Your Ref: MP 09_0187 MOD 3

MODIFICATION REQUEST – SECTION 75W MODIFICATION TO MIXED USE DEVELOPMENT AT 6-16 ATCHISON ST, ST LEONARDS (MO-09_0187 MOD 3)

I refer to your letter dated 2 June 2014 concerning the above matter. The proposed modifications have been reviewed by Council Planners and are not supported the reasons set out below.

NORTH SOUTH SECTION

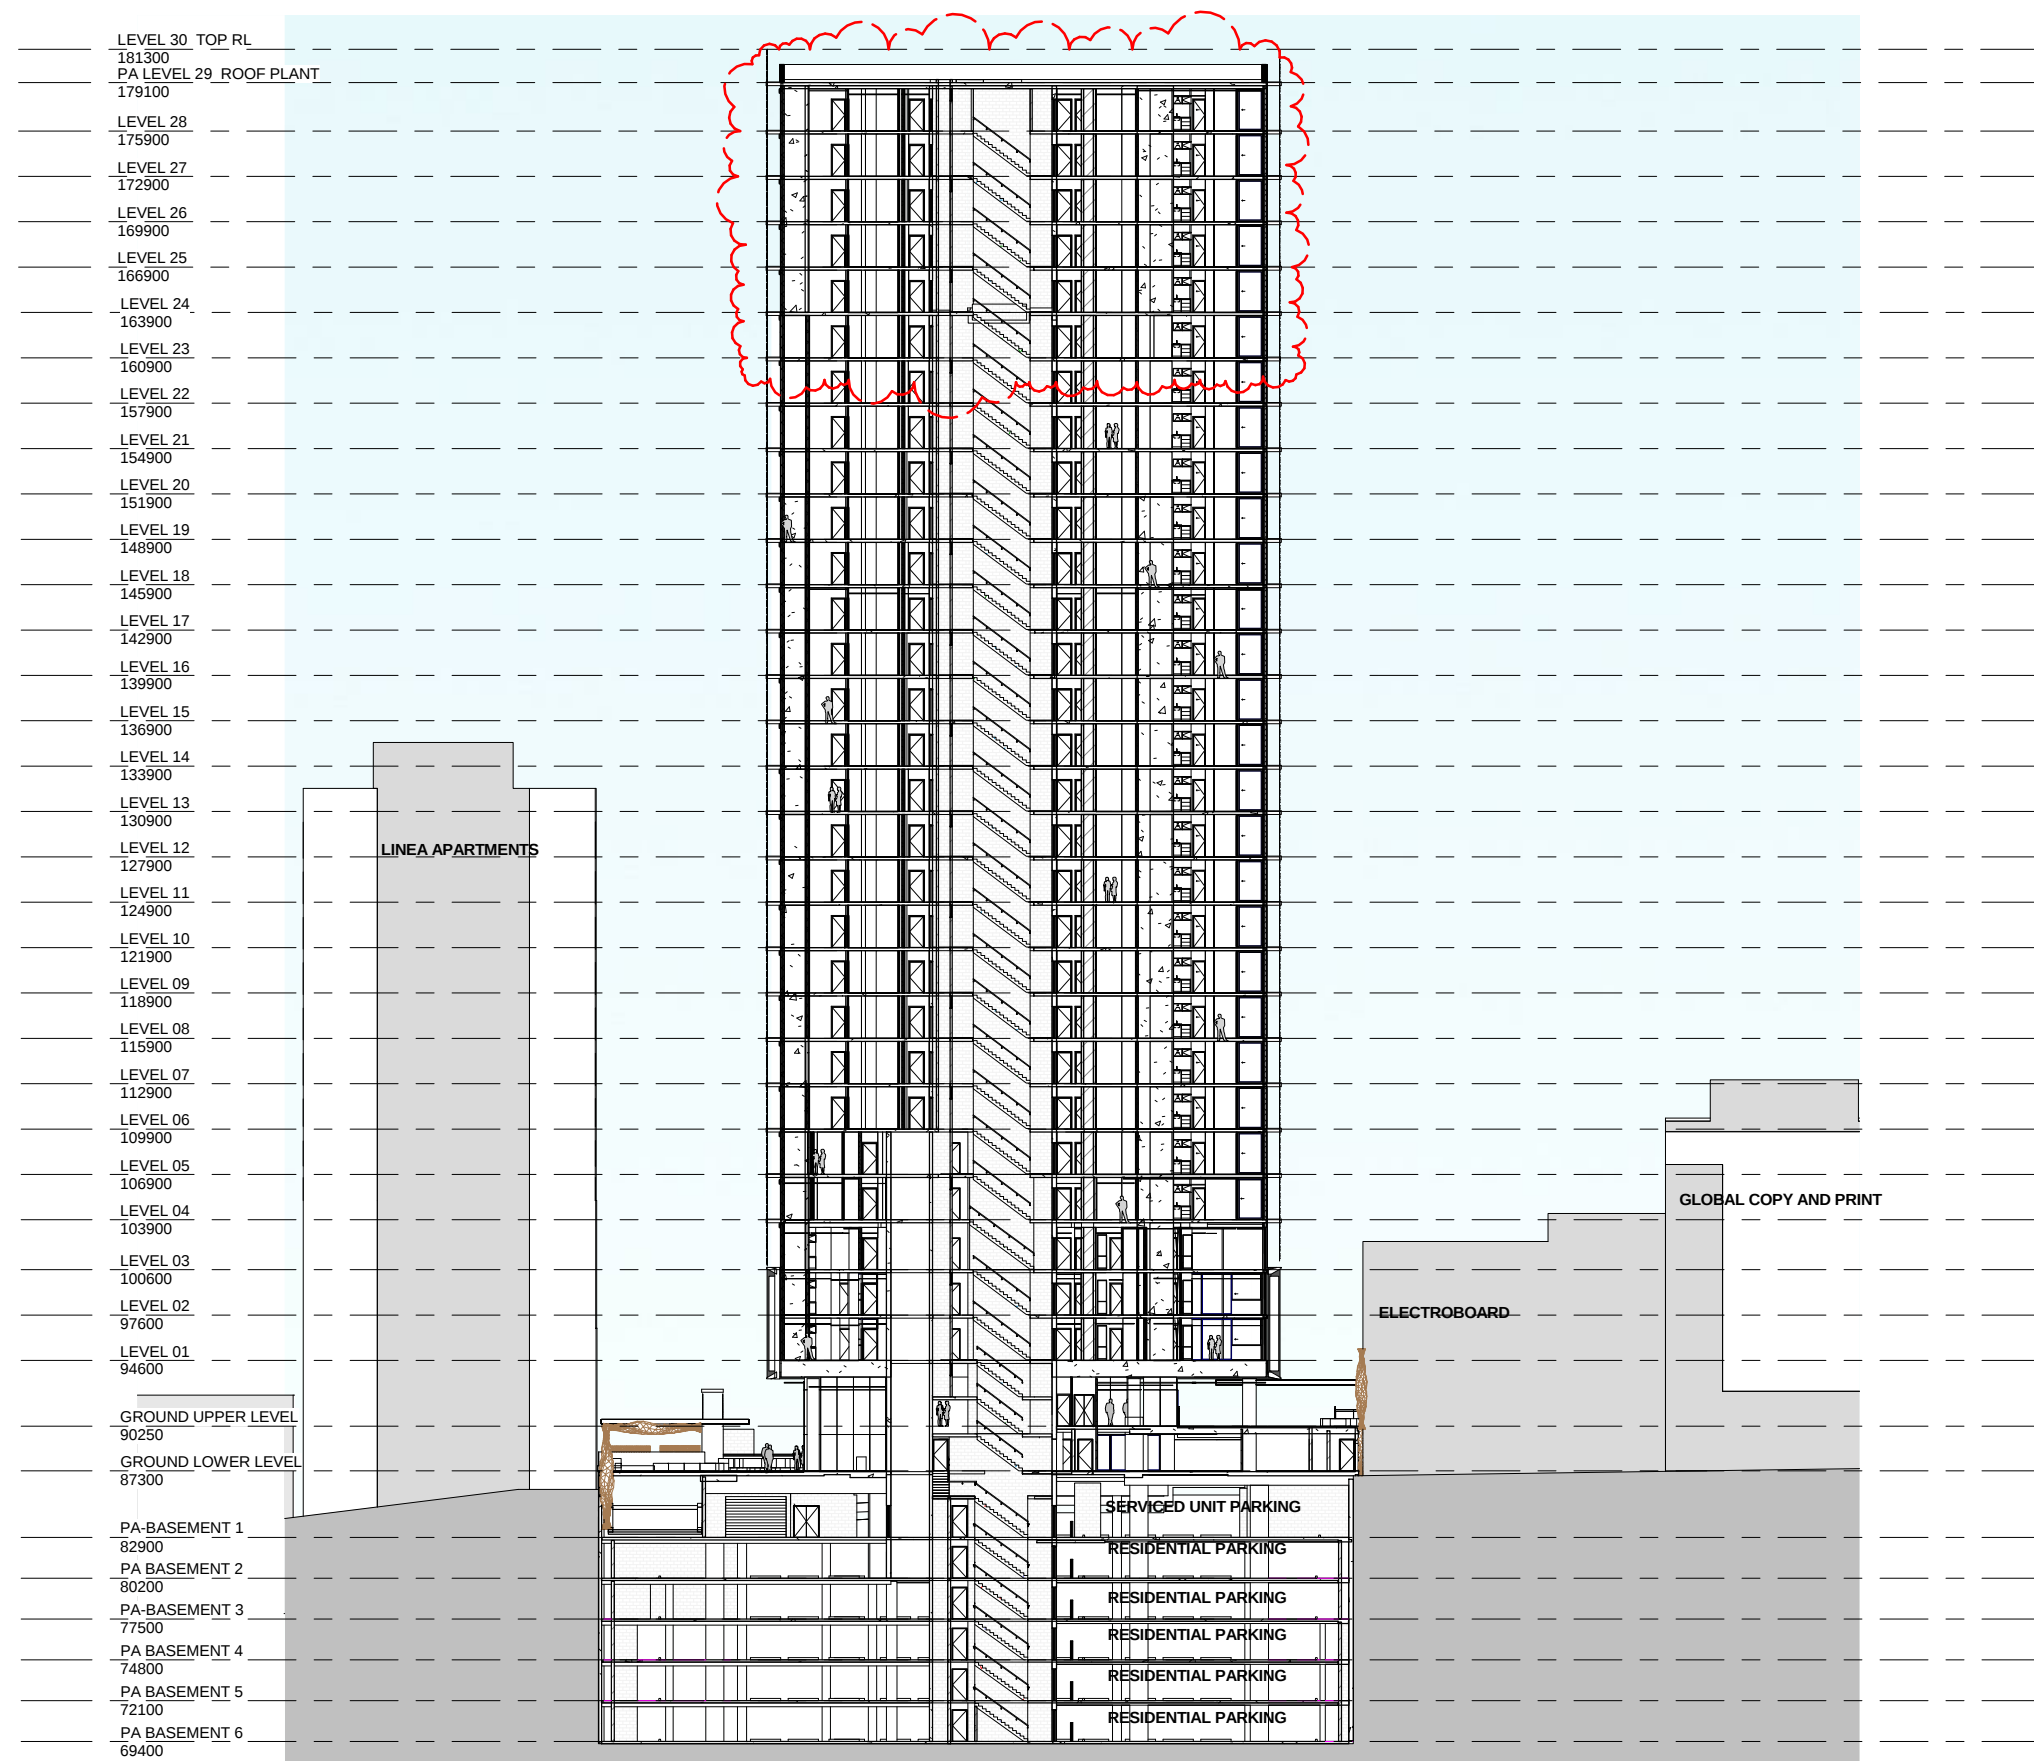
The proposal fails to provide a clear understanding of the proposed height in relation to the local context. Tables comparing the proposal to other buildings combine data in storeys, RLs and metres which does not provide an accurate assessment of the proposed height against the local context, including The Forum. Similarly, the section diagrams are schematic at best.

BASEMENT Level 1

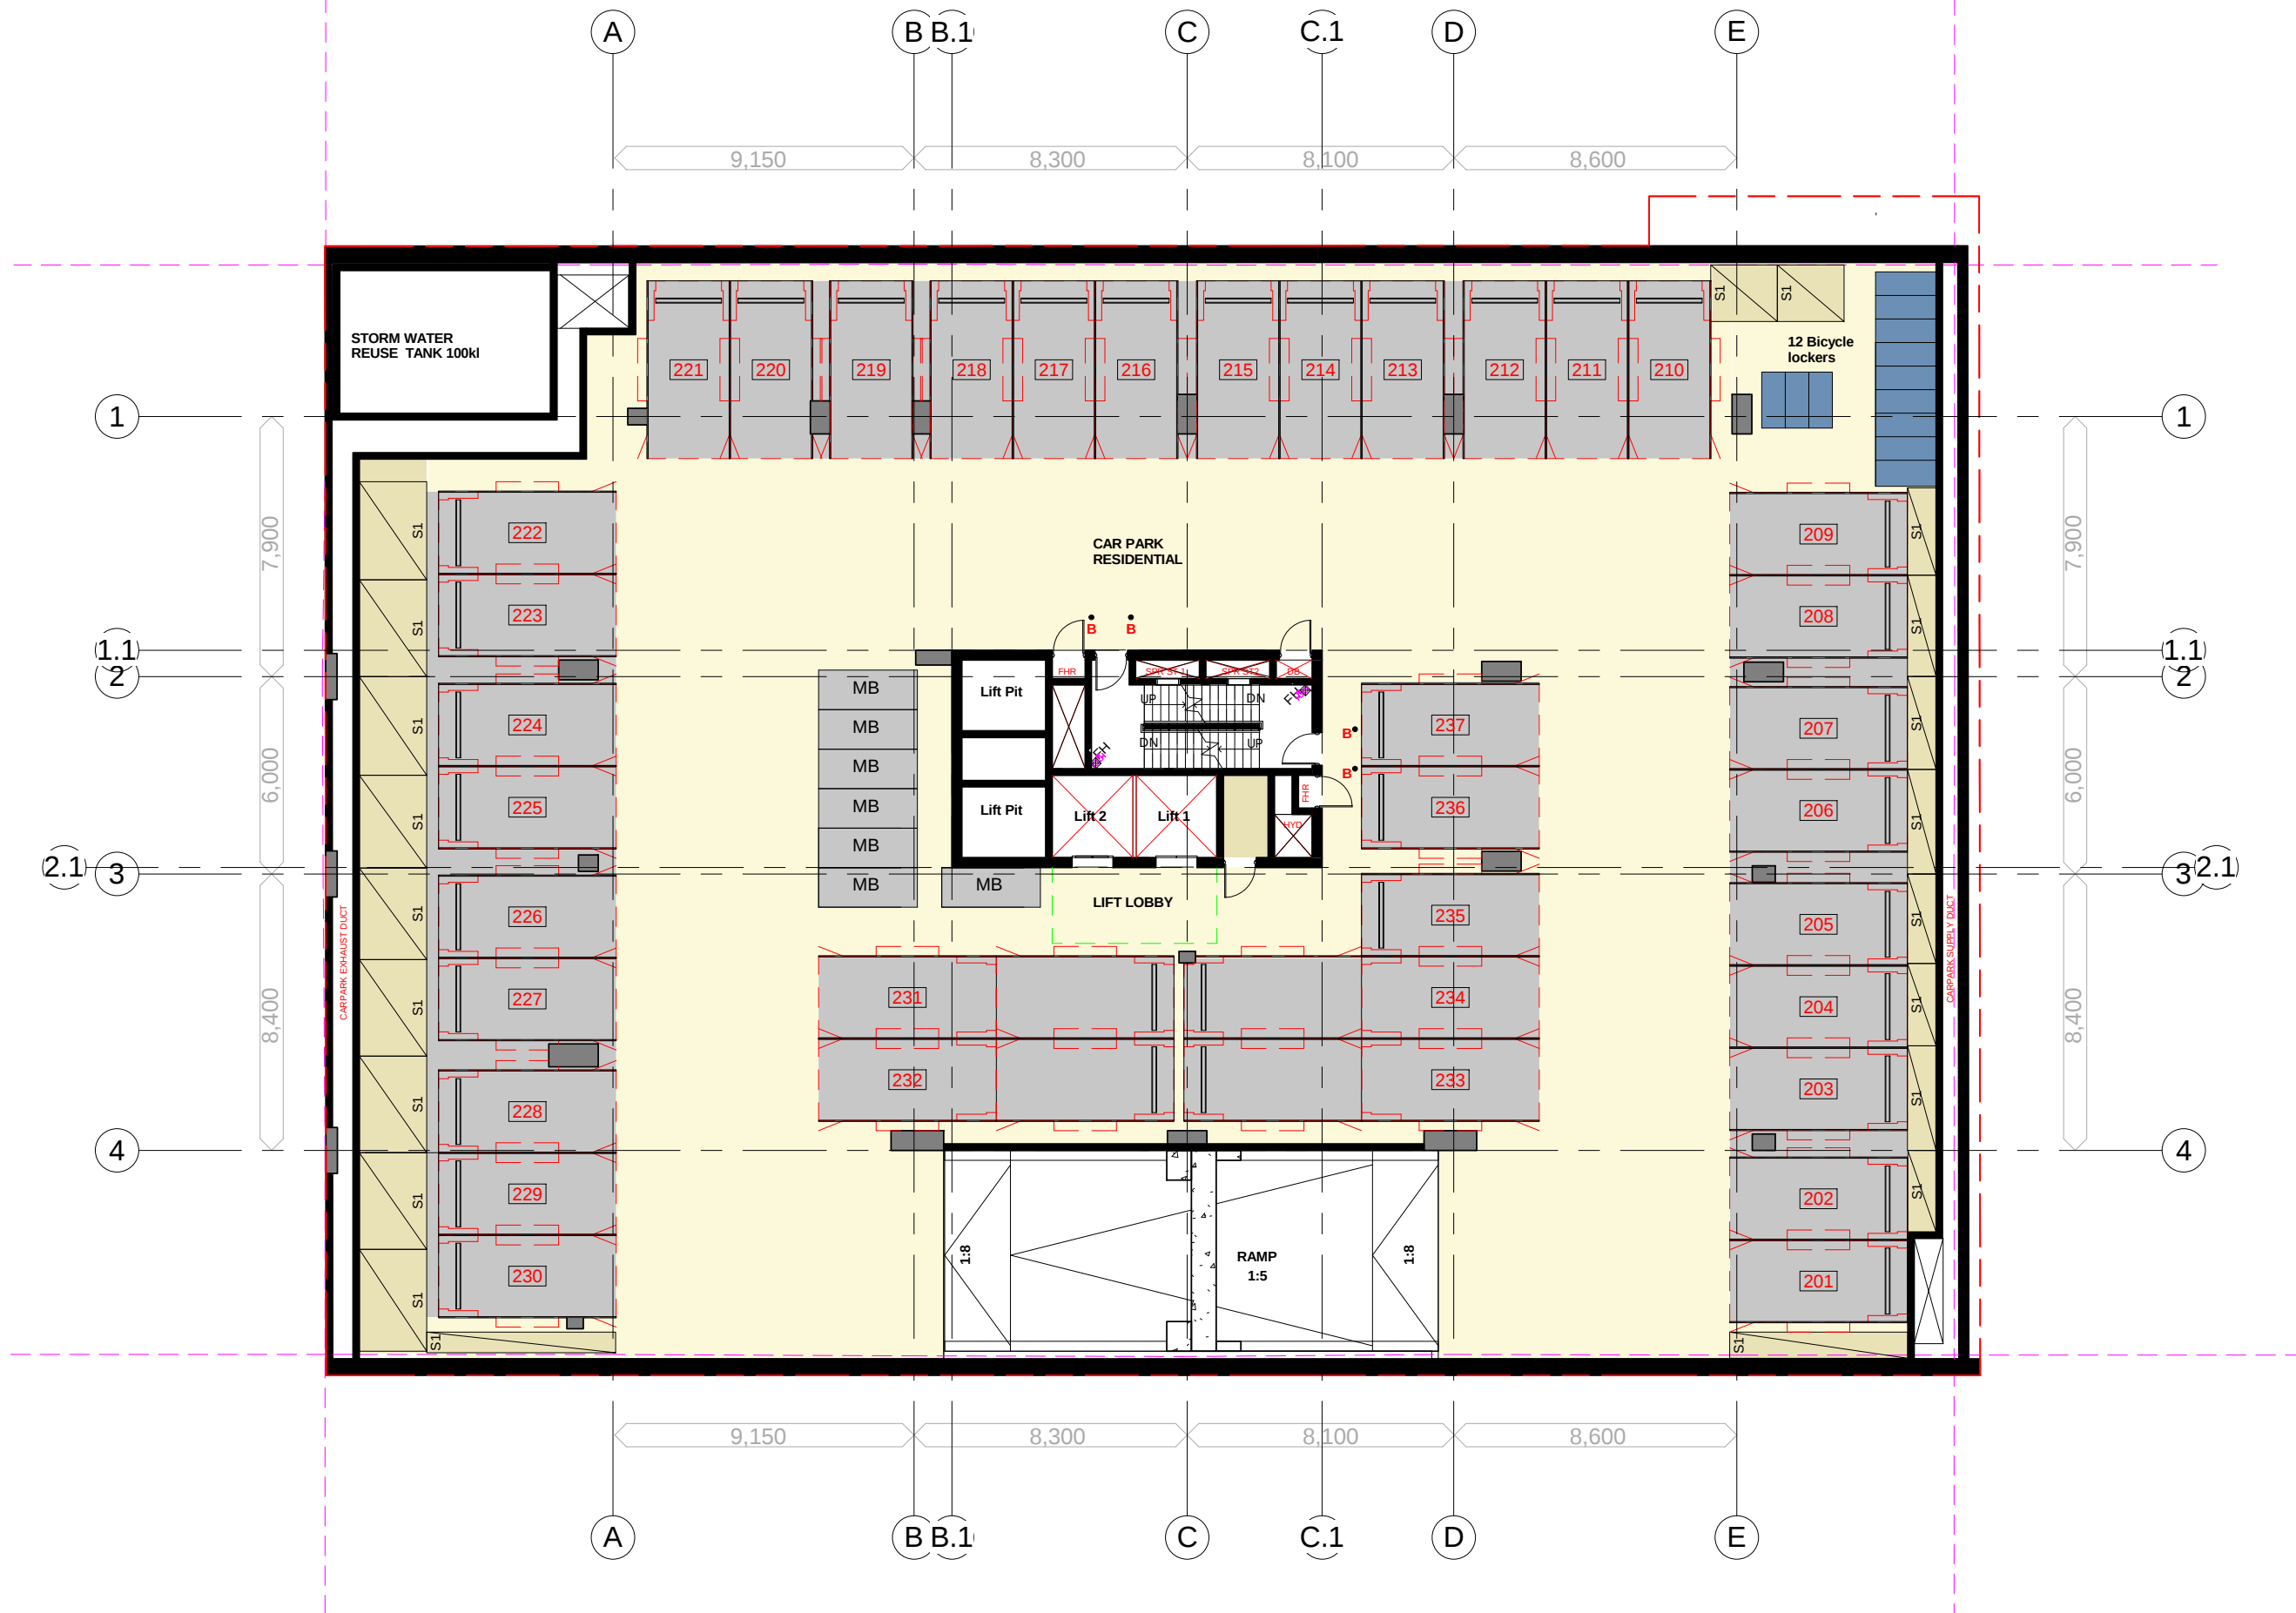
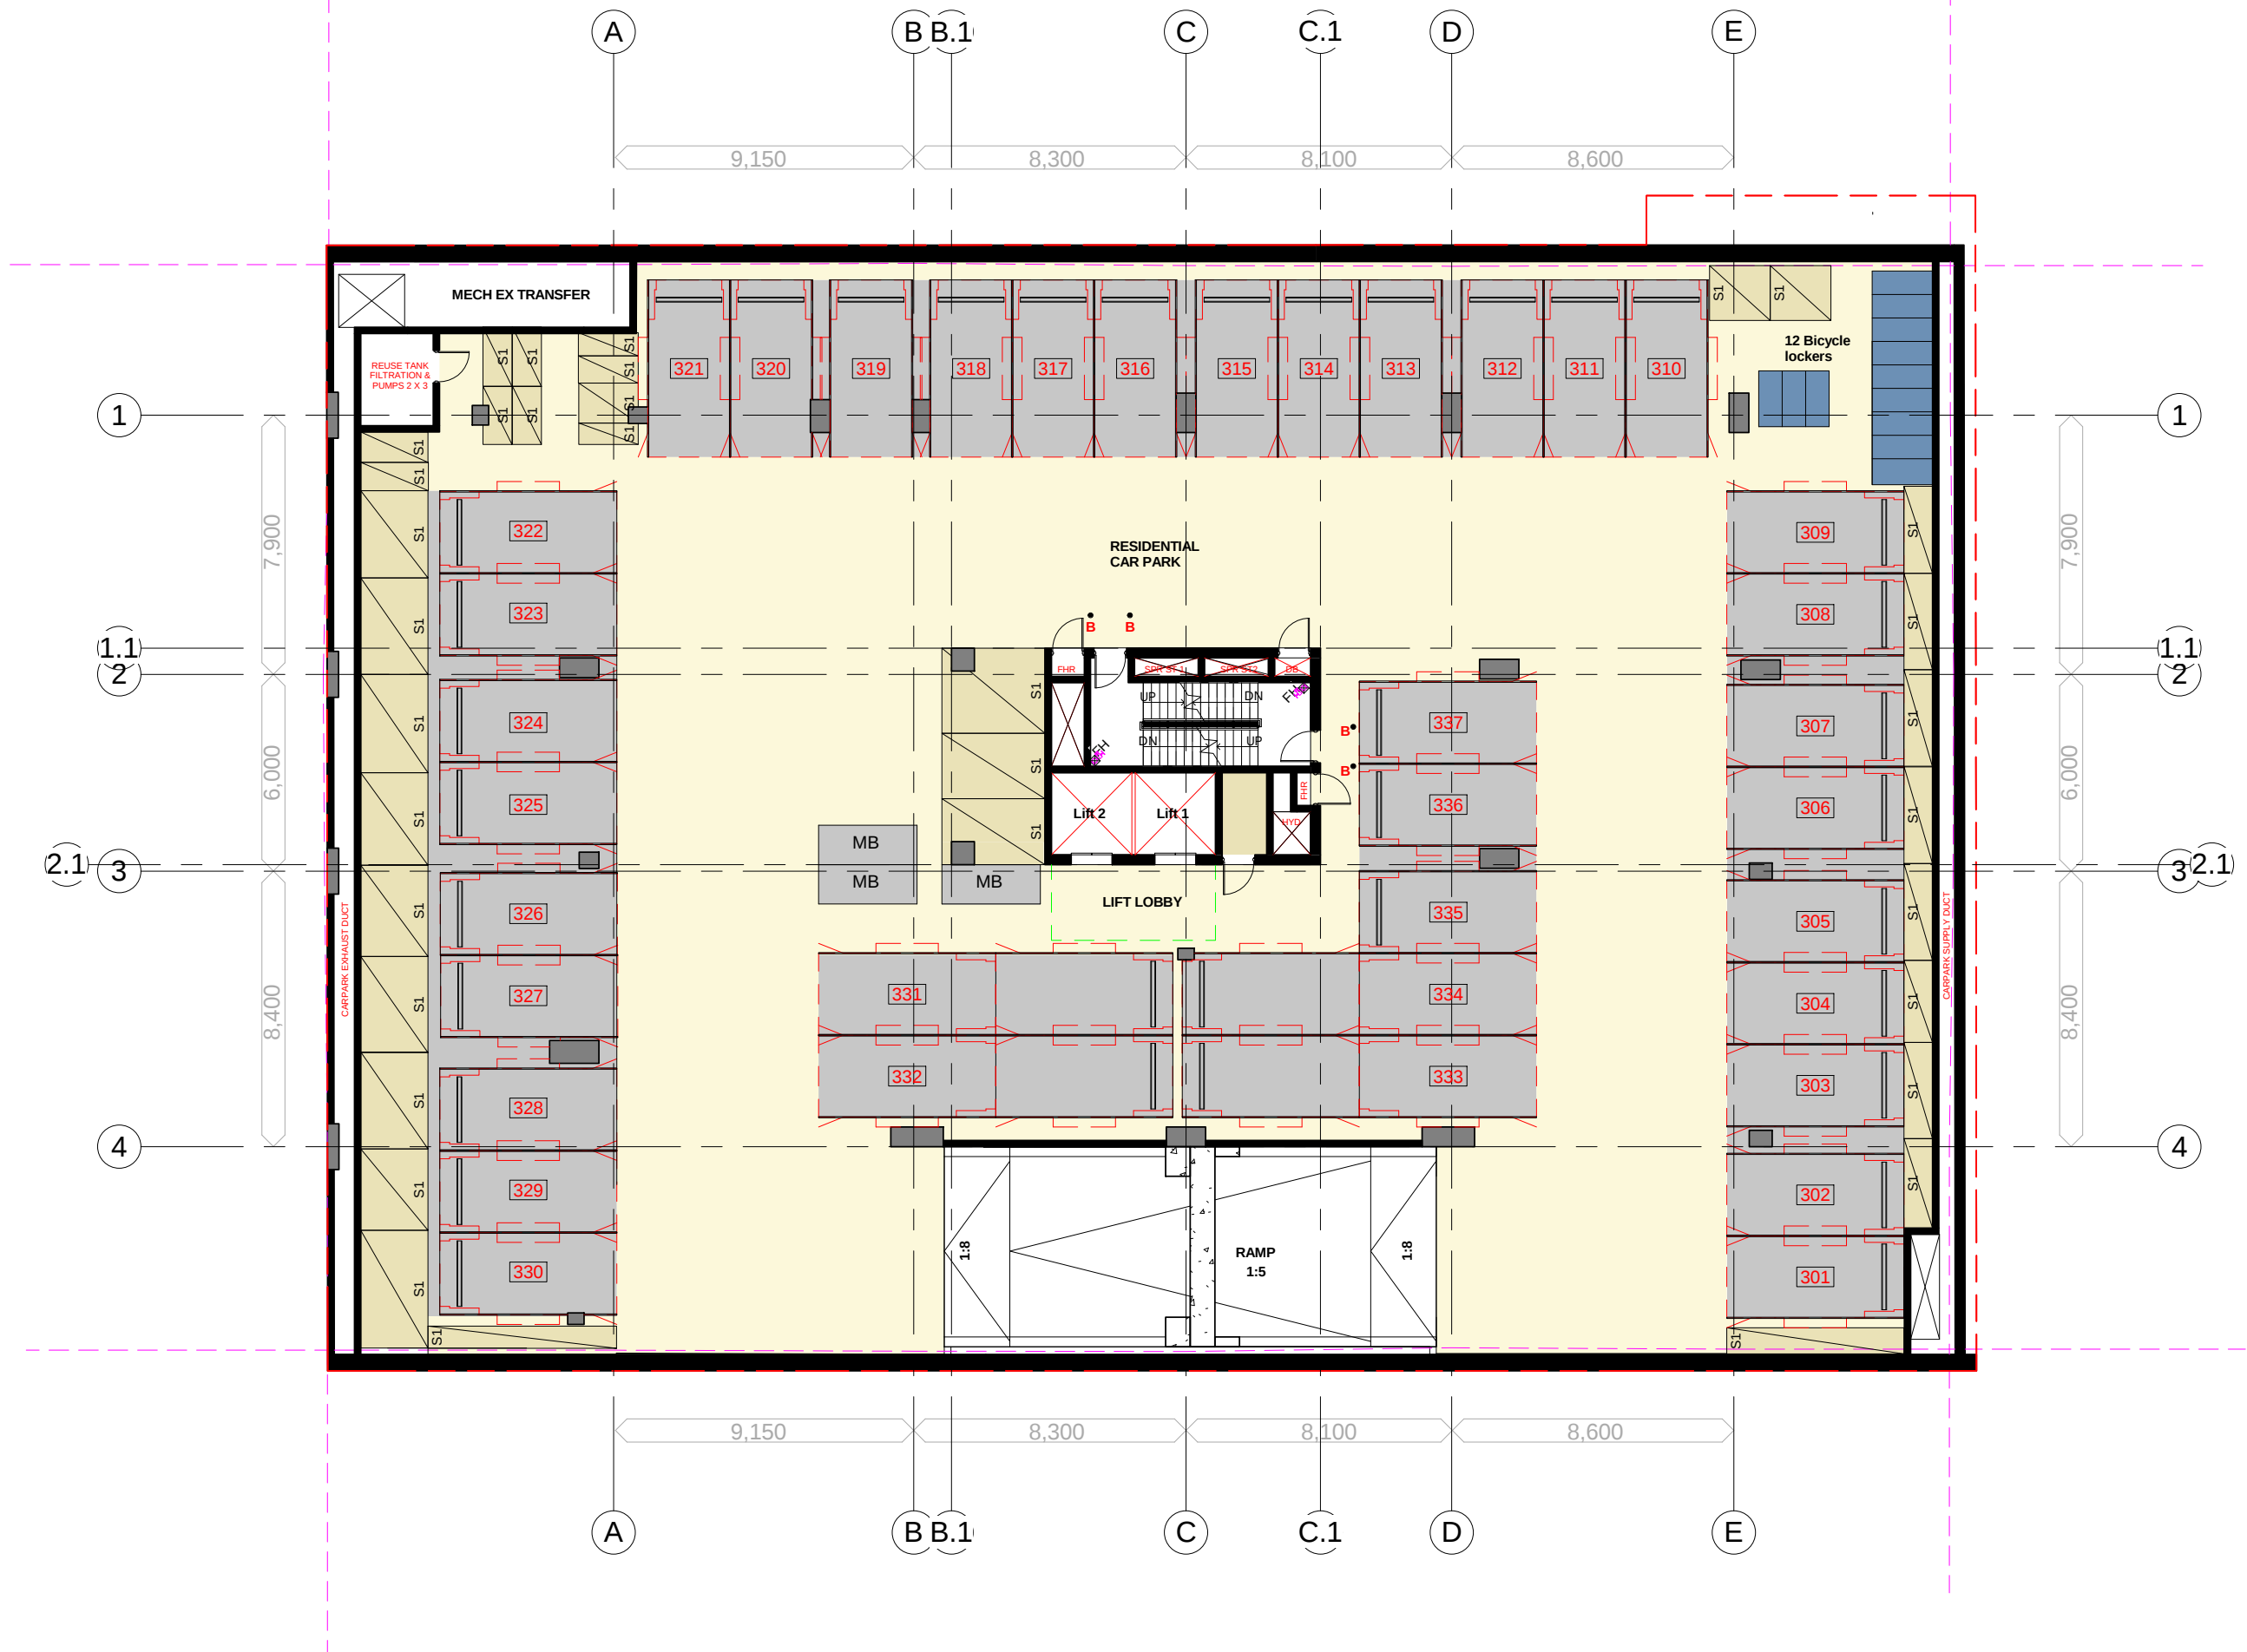
In addition, the modification proposes to provide an additional 34 car parking spaces within the approved 6 basement levels. Concern is raised that the basement has been already approved to accommodate this quantum of additional car parking that has not yet been approved.
